Application for a non-material amendment following a grant of planning permission.

Demolition of side conservatory-type porch and utility space, rebuilt with conventional roof and walls to provide a new en-suite, utility and enlarged entrance lobby

6. Non-Material Amendment(s) Sought

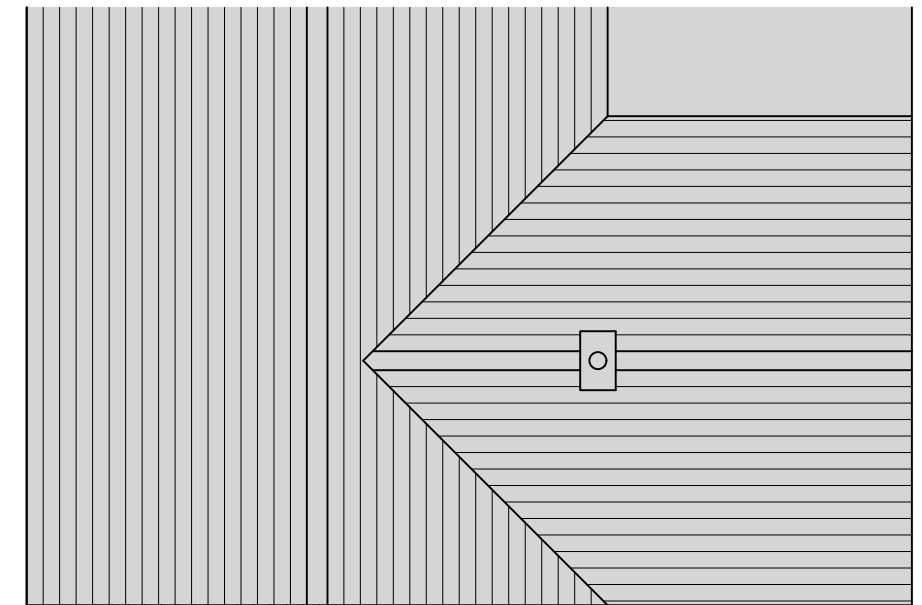
Reduce the size of a window on the East elevation from 1200mm to 660mm. Height remains the same

Altered internal arrangement to enlarge a designated utility area to become an office space as well/instead
